KIRKLEES METROPOLITAN COUNCIL INVESTMENT & REGENERATION SERVICE

Reference No:	2021/44/92901/W
Site Address:	Former Midlothian Garage, New Mill Road, Holmfirth, HD9 7LN
Description:	Discharge of conditions 5 (junction works) and 8 (internal estate roads) of previous outline permission 2015/93824 for erection of 56 dwellings and care home with associated car parking
Recommending Officer:	Nick Hirst

DECISION – Discharge of Conditions – Refuse

Report Dated: 23/08/2024.

S38 STRUCTURAL GENERAL
ARRANGEMENT

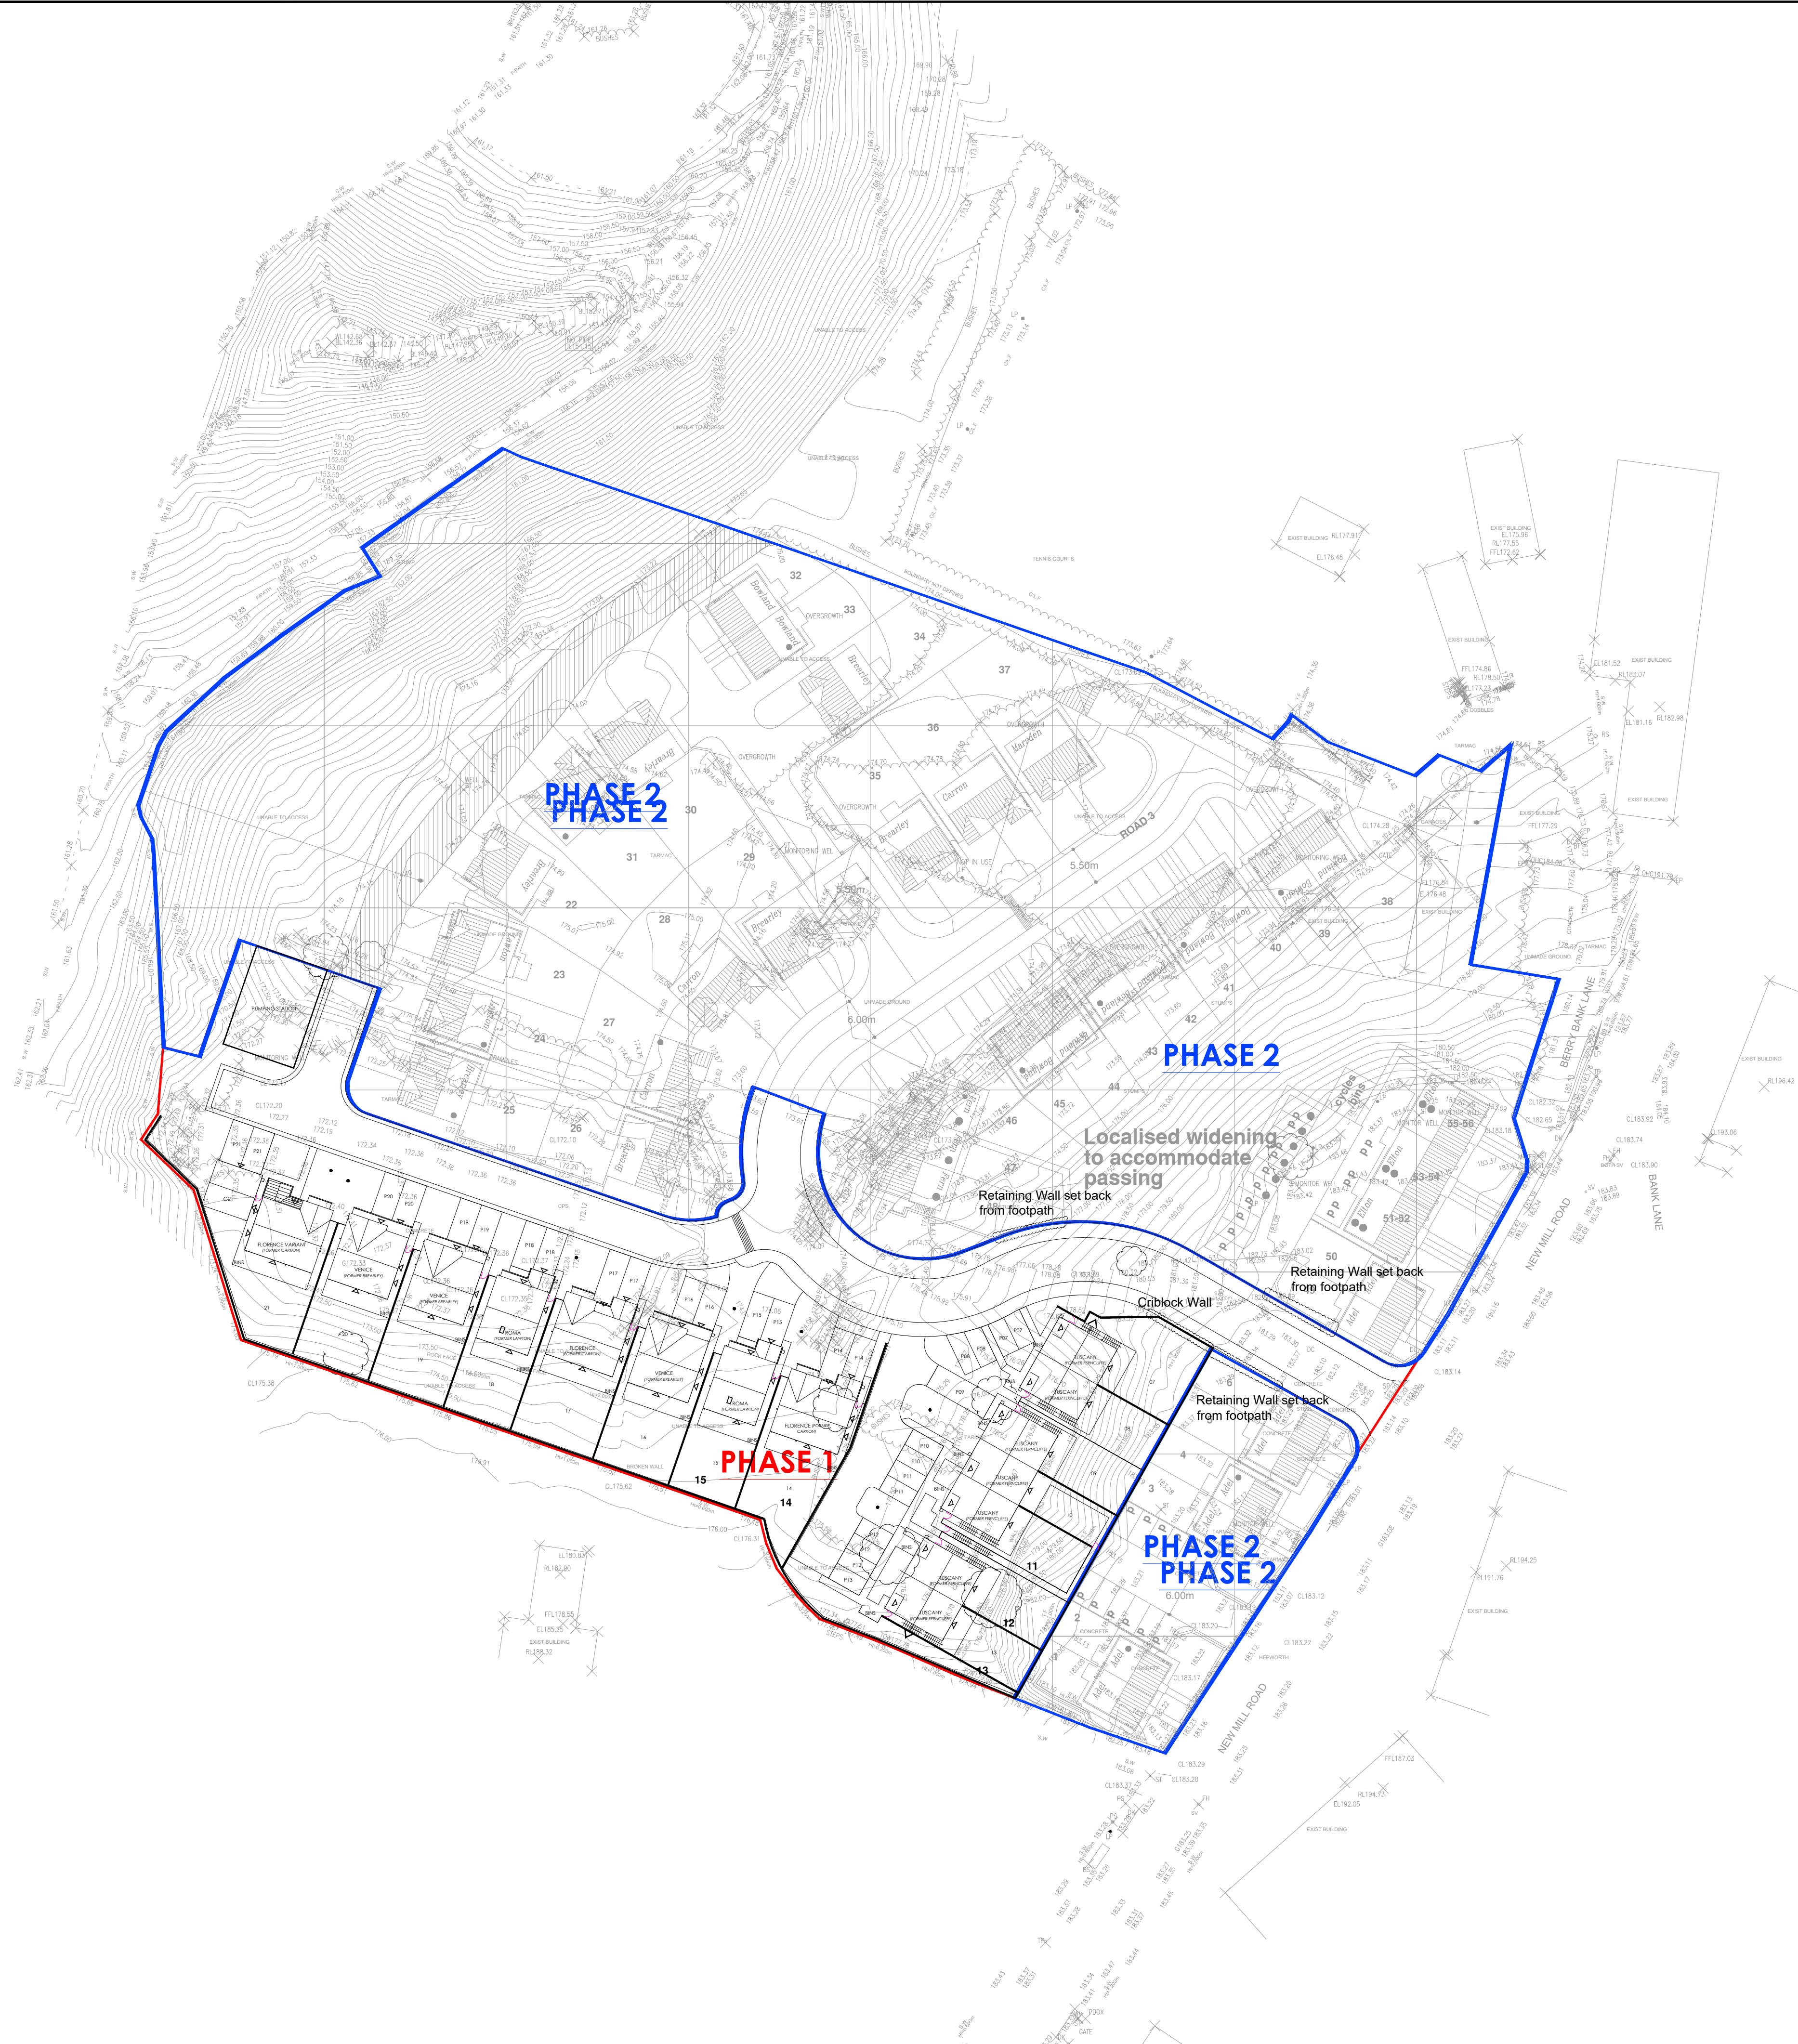
- There is a lack of cross-sectional information, particularly relating to highway retaining features;
- The drainage proposals are not satisfactory, including unacceptable gully locations and road levels/contours;
